EPA Request for more Information on Environmental Impacts

Thank you for the request for advice from Public Authority Consultation (PAE-32670512), requesting the review by the NSW Environment Protection Authority (EPA) of the Environmental Impact Assessments for the proposed Second Thermal Oxidiser (Application DA246/96 MOD-4) at Terminals P/L, 45 and 51 Friendship Road, Port Botany (the premises).

Attachment A – EPA review of the AQIA for Mod-4

Figures

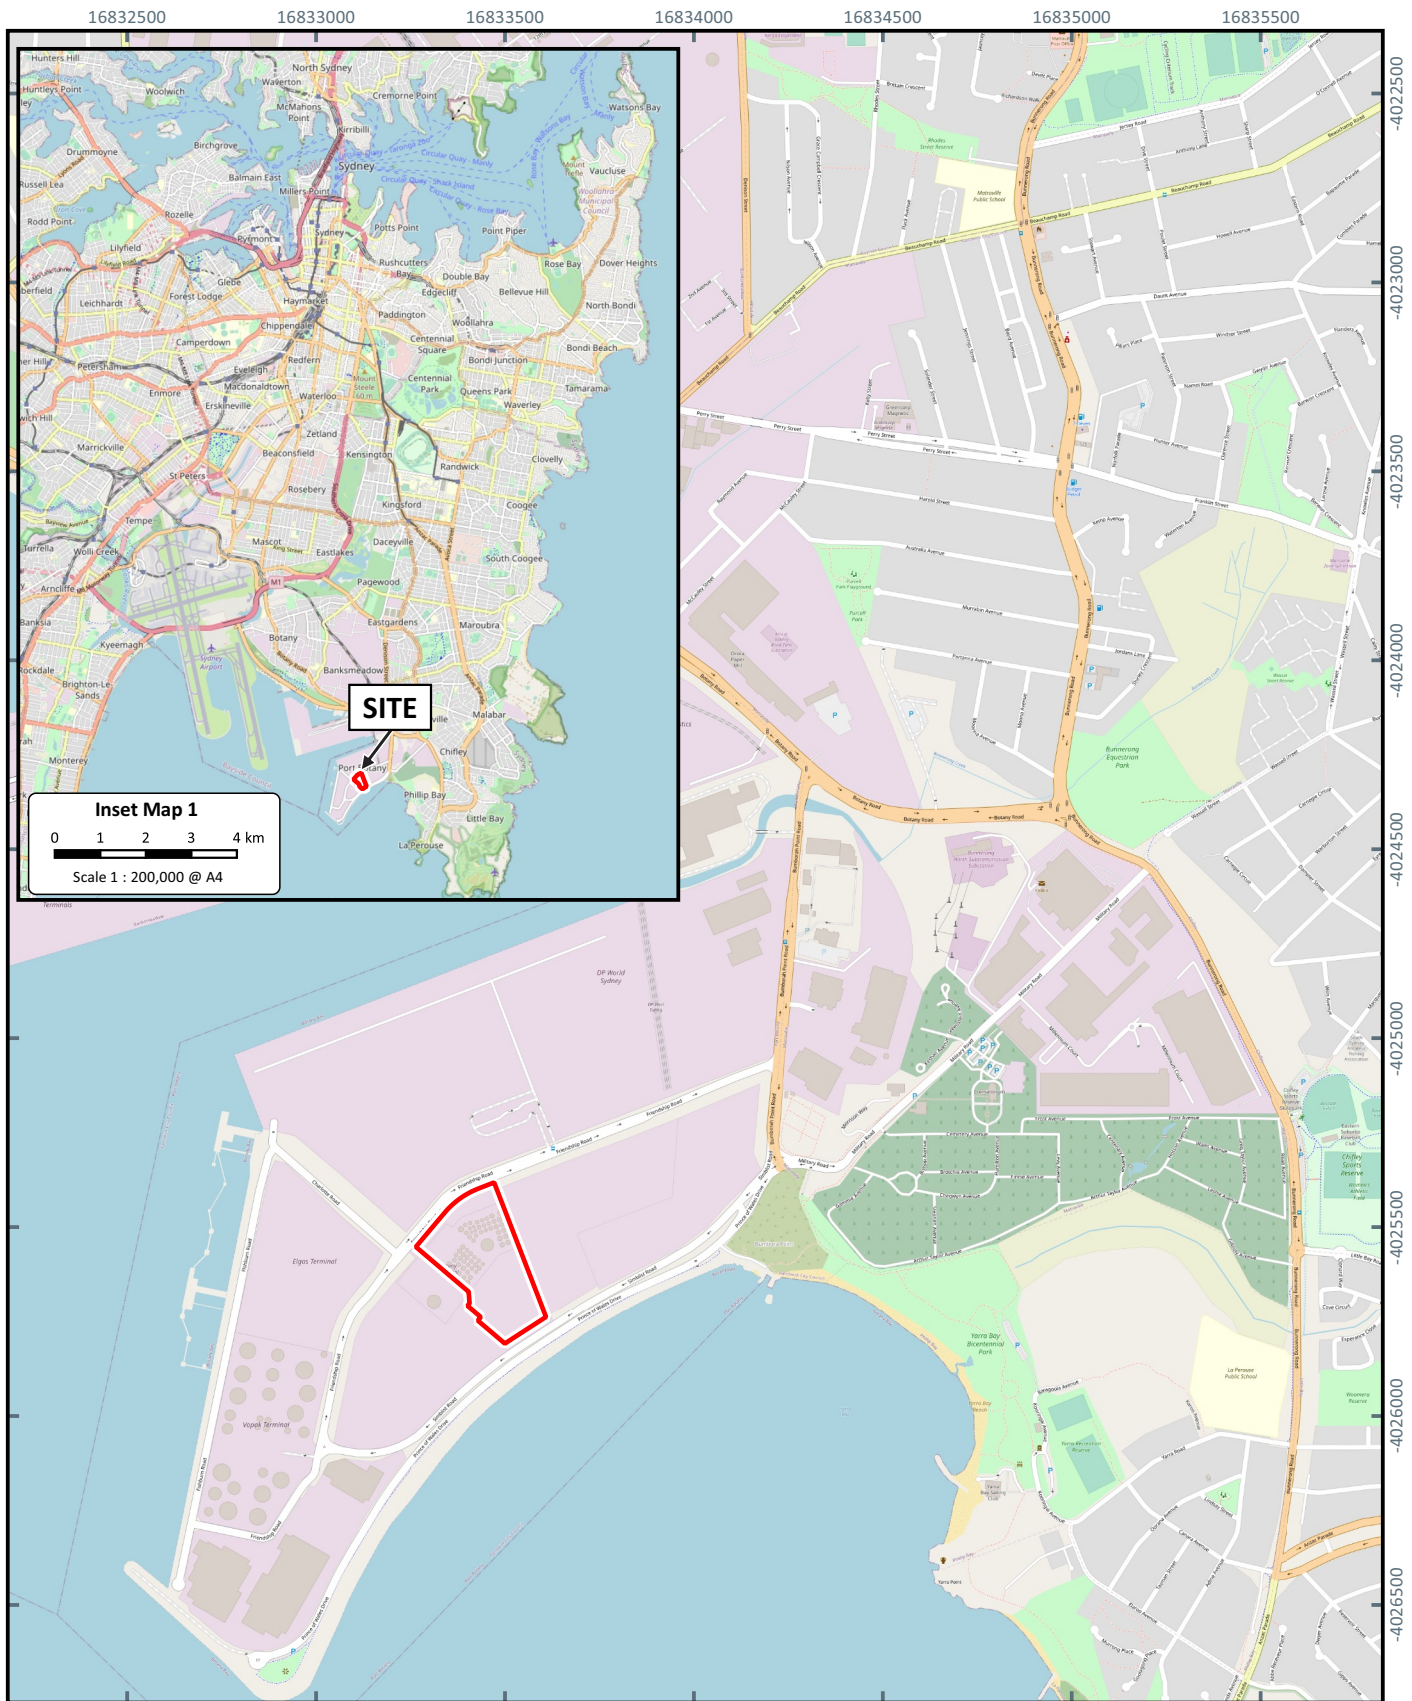
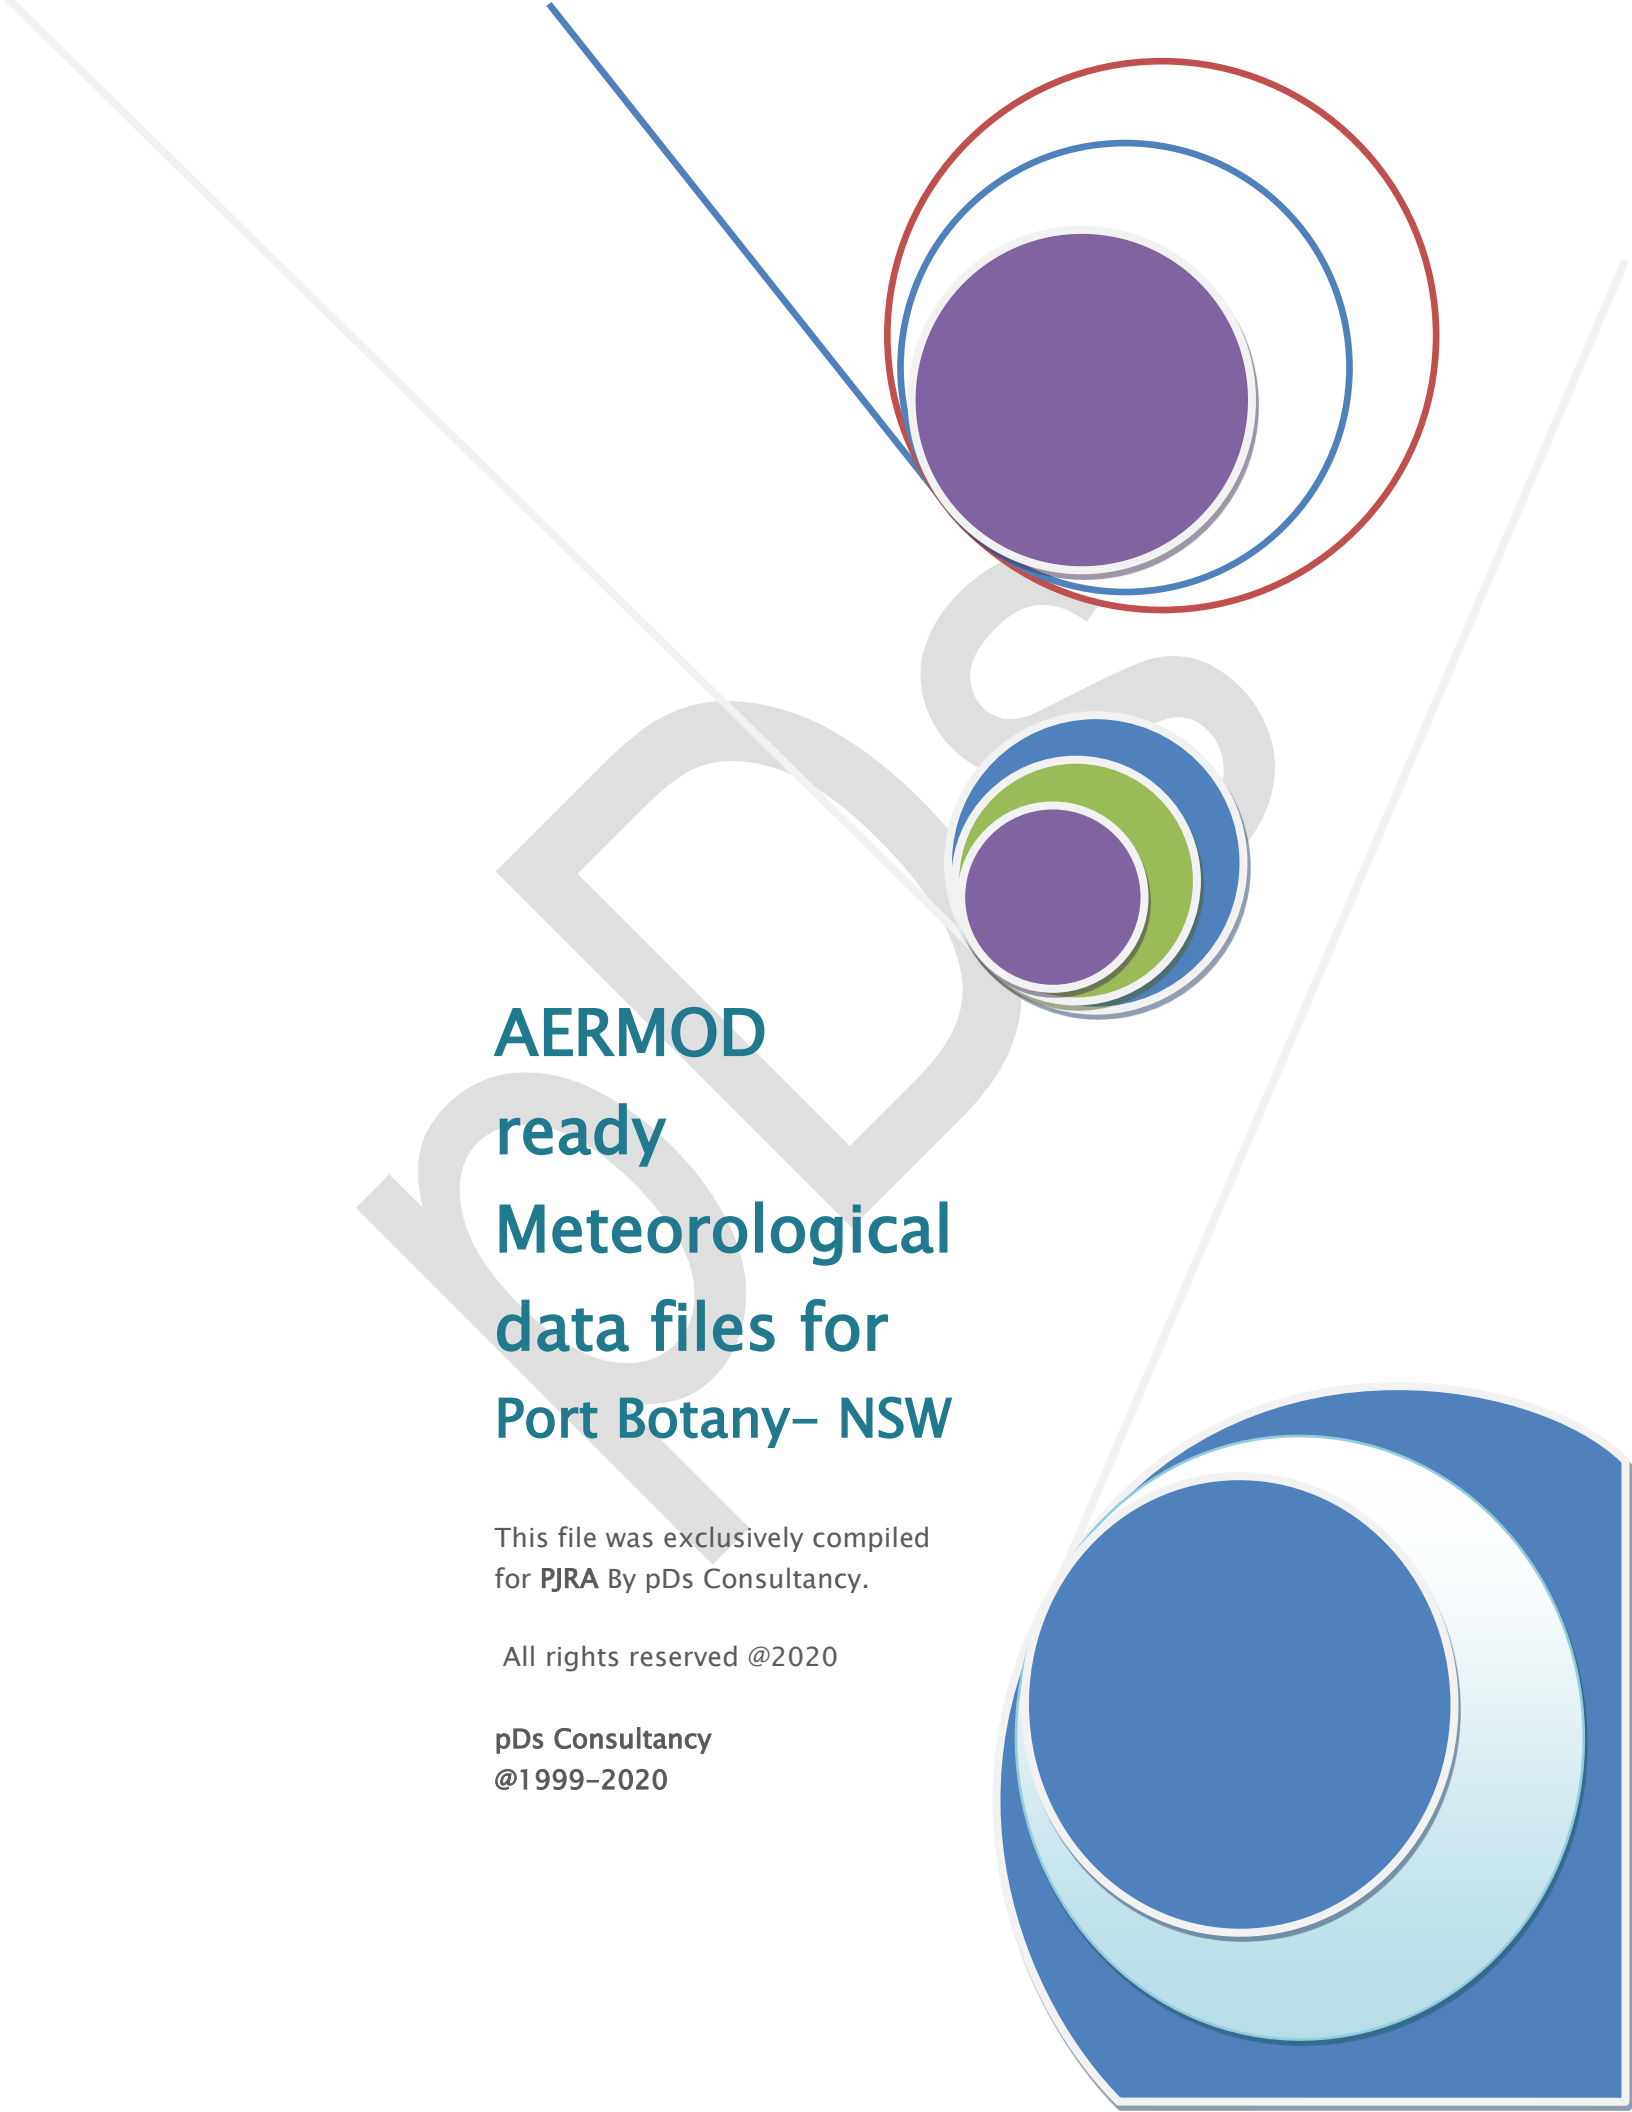
Despite all these inconsistent and unclear emission concentration, parameters and emission rates, the predicted impacts (Tables 9, 10, 11 and 12, Figures F3, F4, F5 and F6) remain exactly the same as presented in the revised AQIA for Mod3. Figure F3 of the predicted impacts remain dated 10/2/2021 which indicates the model has not been updated to reflect changes made as outlined above.

The EPA recommends that the proponent either confirm that the predicted impacts remain valid or remodel them using the correct and updated emission parameters. This should include modelling existing sources at licence limits, clearly outlining the expected emissions performance of the proposed thermal oxidiser in the main AQIA and correcting inconsistent or incorrect emission parameters.
